Ribble Valley Borough Council
Planning Section
Council Offices
Church Walk
Clitheroe
BB7 2RA

Planning Application No: 3/2024/0766

Proposal: Proposed conversion of barn to one new dwelling with associated parking and amenity space.

Location: Old Vicarage Farm Talbot Bridge Road Bashall Eaves BB7 3DB

Drawing Title
BLOCK PLAN

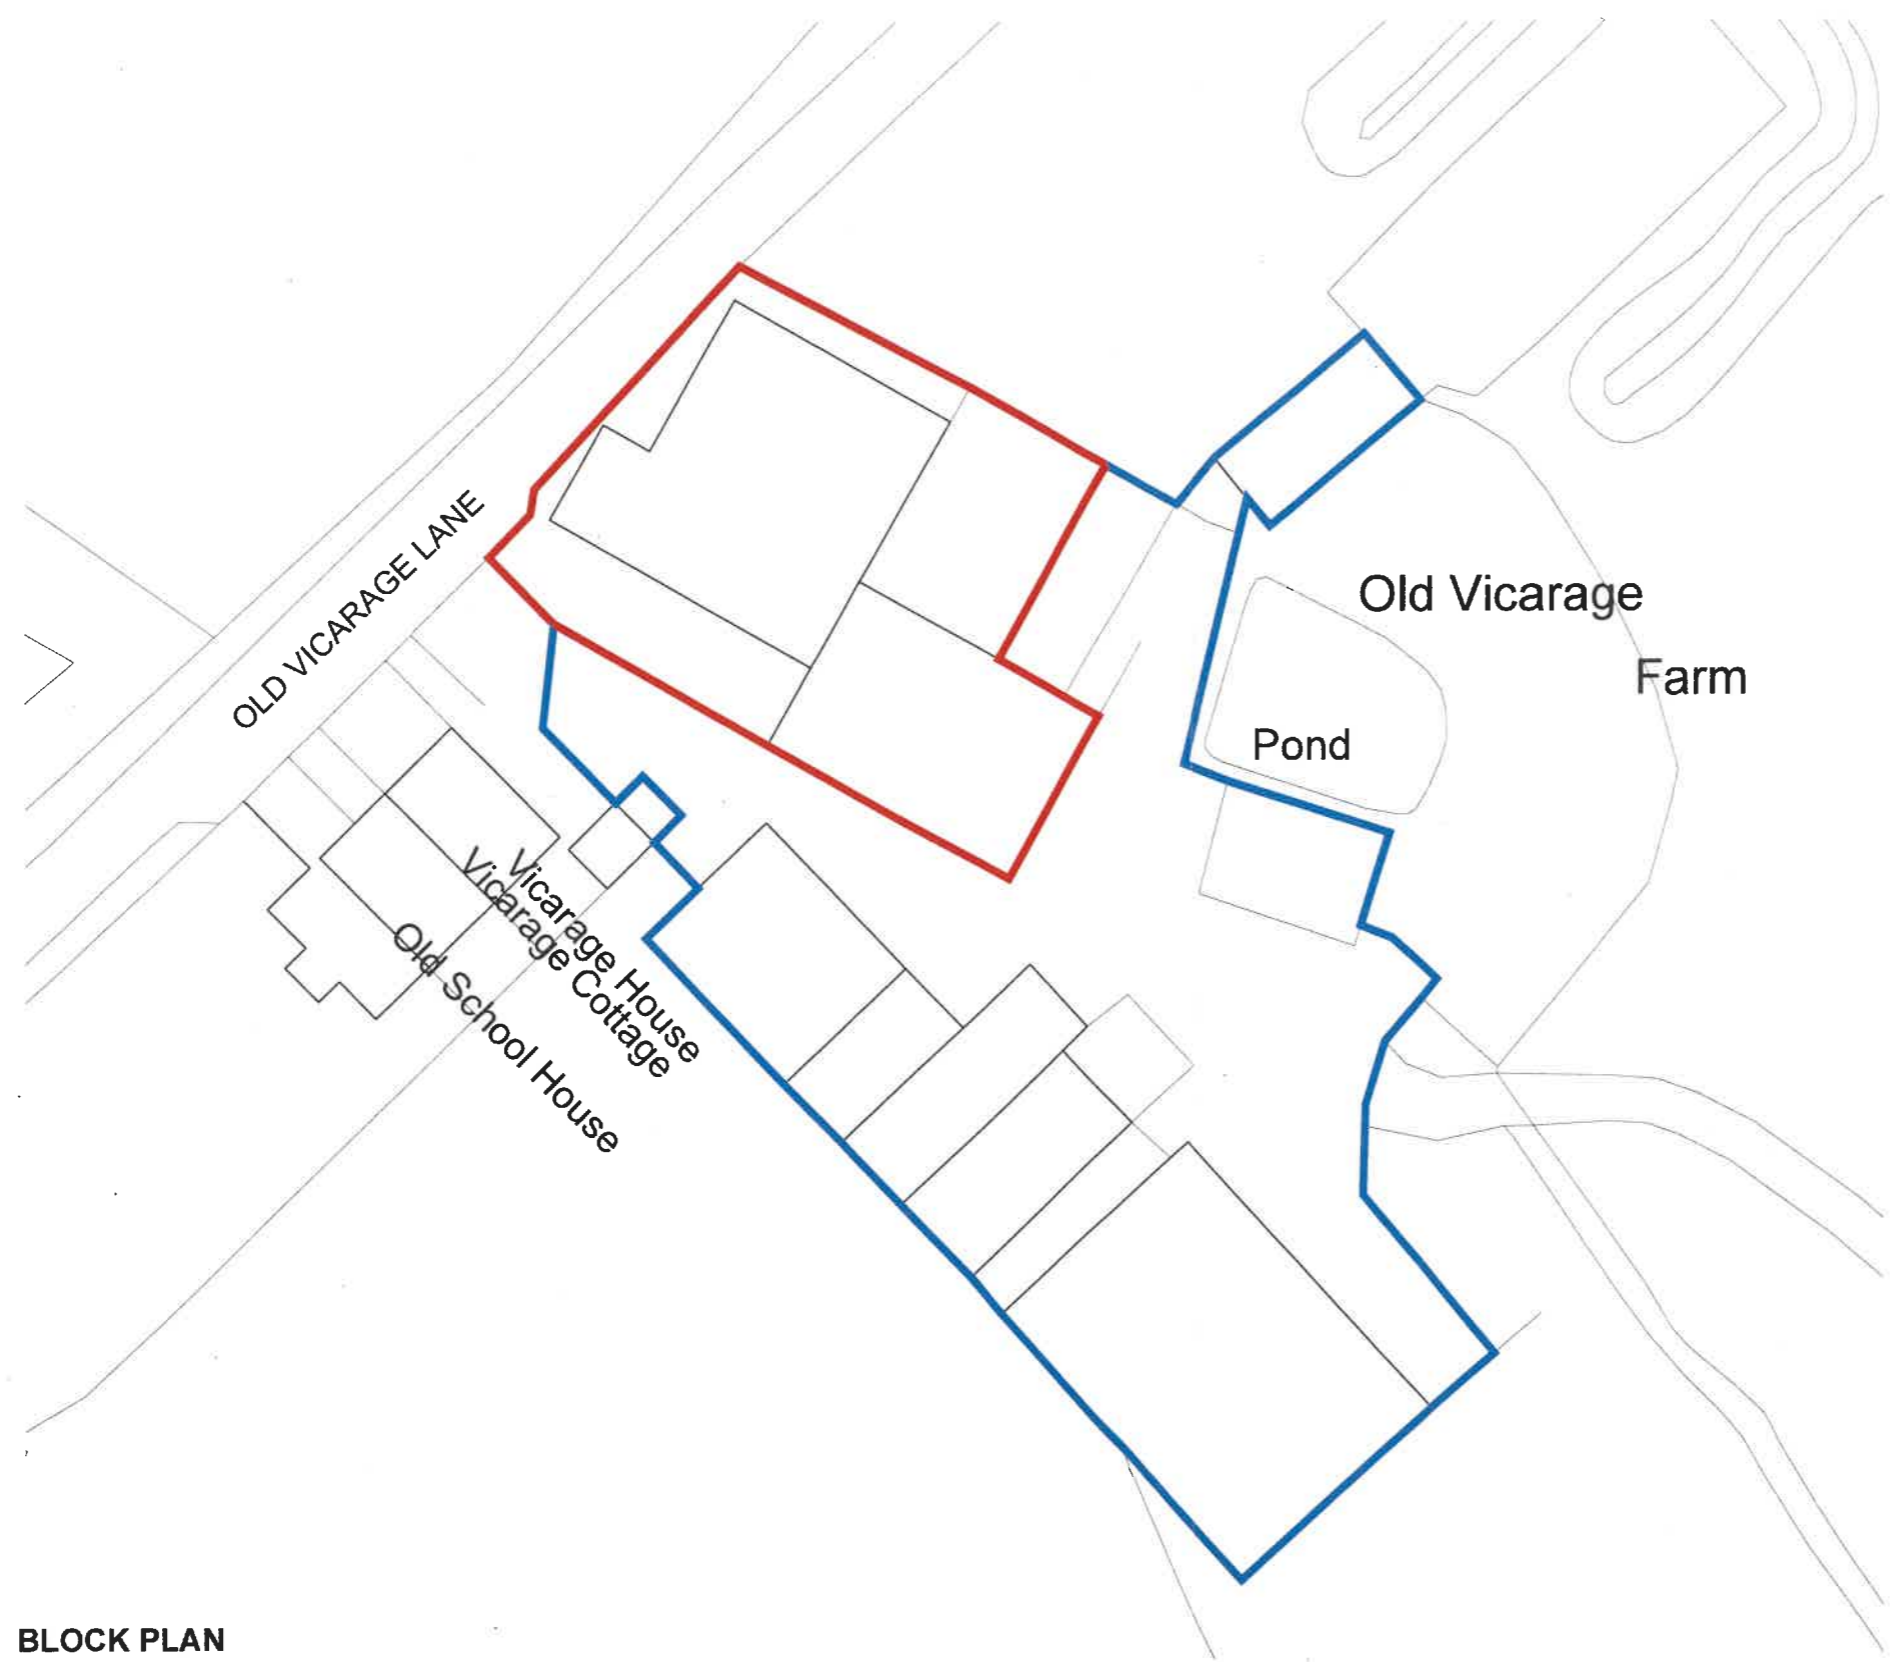
With Ref planning statement submitted 5.2 Highways and Access. The LHA has reviewed proposed site plan and is aware that the site access will remain unaltered following the proposal, no accidents have been recorded within the last 5 years within the vicinity of the access.

Ref Proposed site plan, June 2024 3 parking spaces are proposed for this 4 bed dwelling. This meets parking standards requirement.

Therefore, the development shall include covered secure cycle storage for a minimum of 4 bicycle spaces to ensure the provision and availability of adequate cycle parking for each resident and the promotion of sustainable forms of transport. Additionally, it is expected that a charging point for electric vehicles is included in the development to promote sustainable modes of transport. The DfT guidance regarding Electric Vehicle Charging in Residential and Non-residential buildings states charge points must have a minimum power rating output of 7kW and be fitted with a universal socket that can charge all types of electric vehicles.
